Consultation Response from: KC Environmental Health (Pollution & Noise Control)
2020/92777 - adj, 22, Gib Lane, Skelmanthorpe, Huddersfield, HD8 9BG
Erection of detached dwelling
Date Responded:
23 October 2020

Responding Officer:
Natalie Heaney

Responding Ref:
WK/202028753

Drg No:
GL 03 B

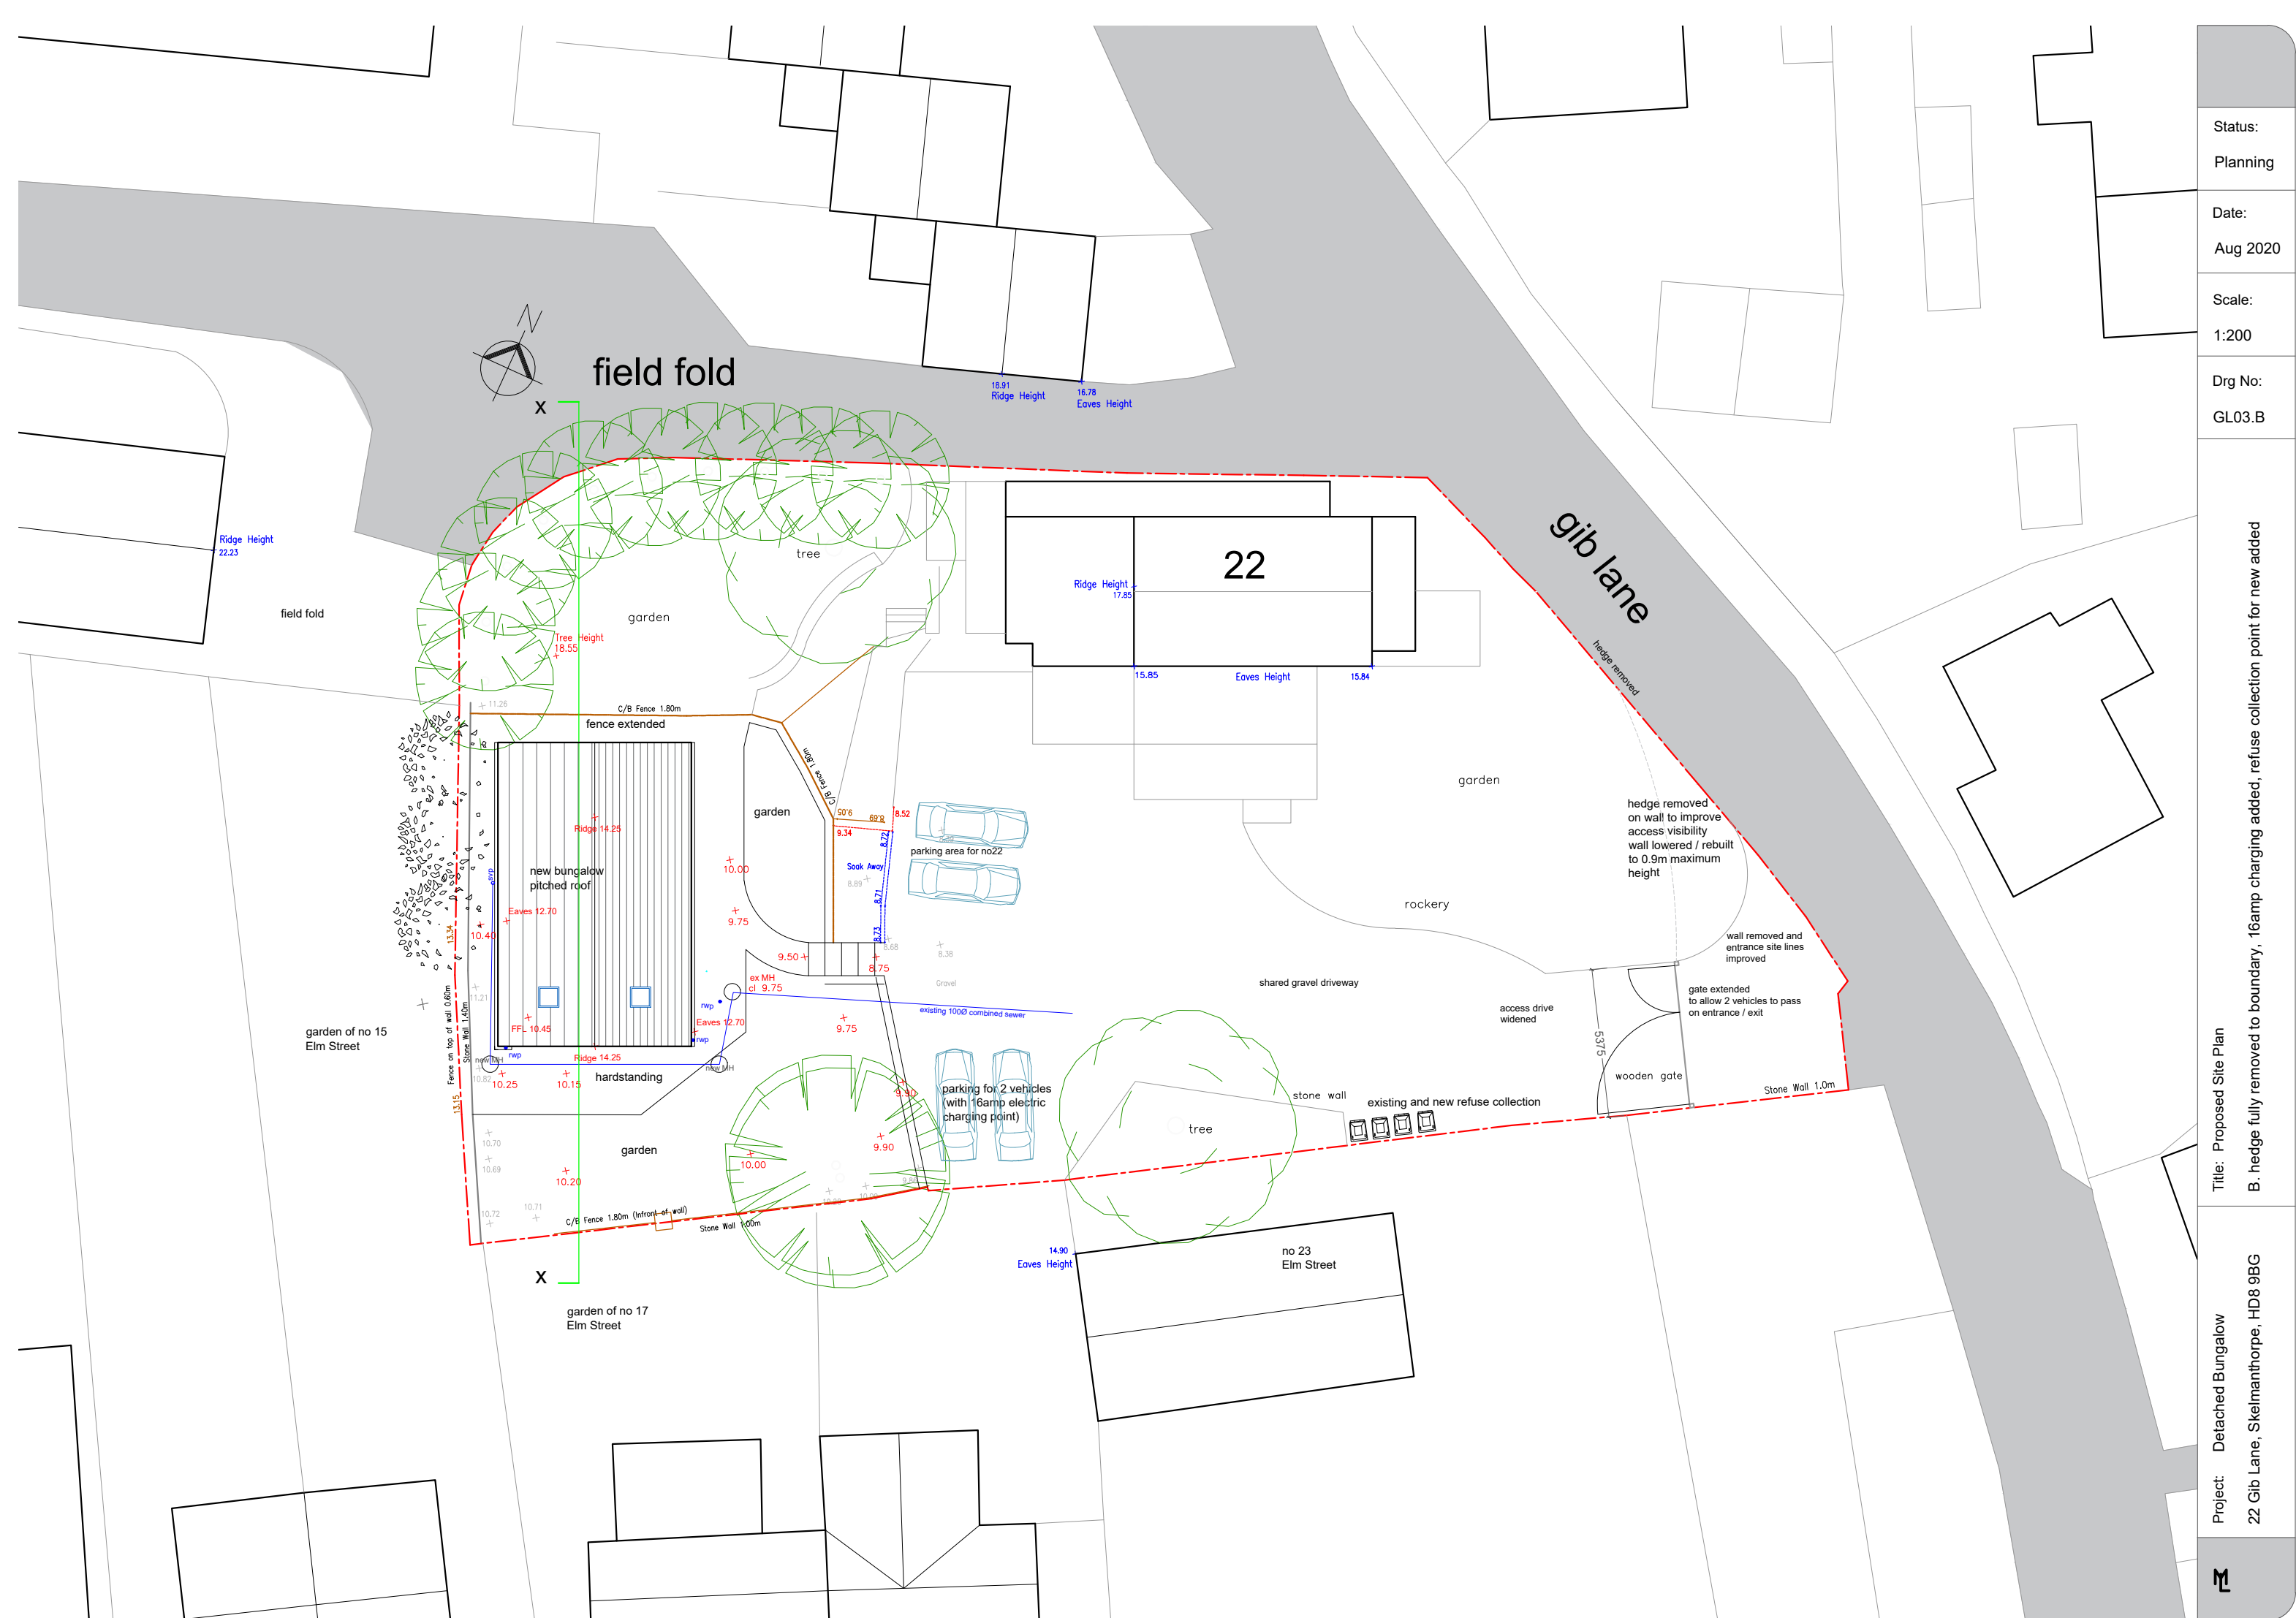
The application forms specify no proposed changes in parking spaces. However, in the proposed site plan, dated August 2020 (ref: drawing no. GL03.#) there is reference to electric vehicle charging points for 2 vehicles. In an application of this nature it is expected that facilities for charging electric vehicles and other ultra-low emission vehicles are provided in accordance with the National Planning Policy Framework and Air Quality & Emissions Technical Planning Guidance from the West Yorkshire Low Emissions Strategy Group. A condition relating to charging points is therefore necessary.

Before the electrical system is installed a scheme detailing the dedicated facilities that will be provided for charging electric vehicles and other ultra-low emission vehicles shall be submitted to and approved in writing by the Local Planning Authority. The scheme shall meet at least the following minimum standard for numbers and power output:

- A Standard Electric Vehicle Charging point providing a continuous supply of at least 16A (3.5kW) for each residential unit that has a dedicated parking space
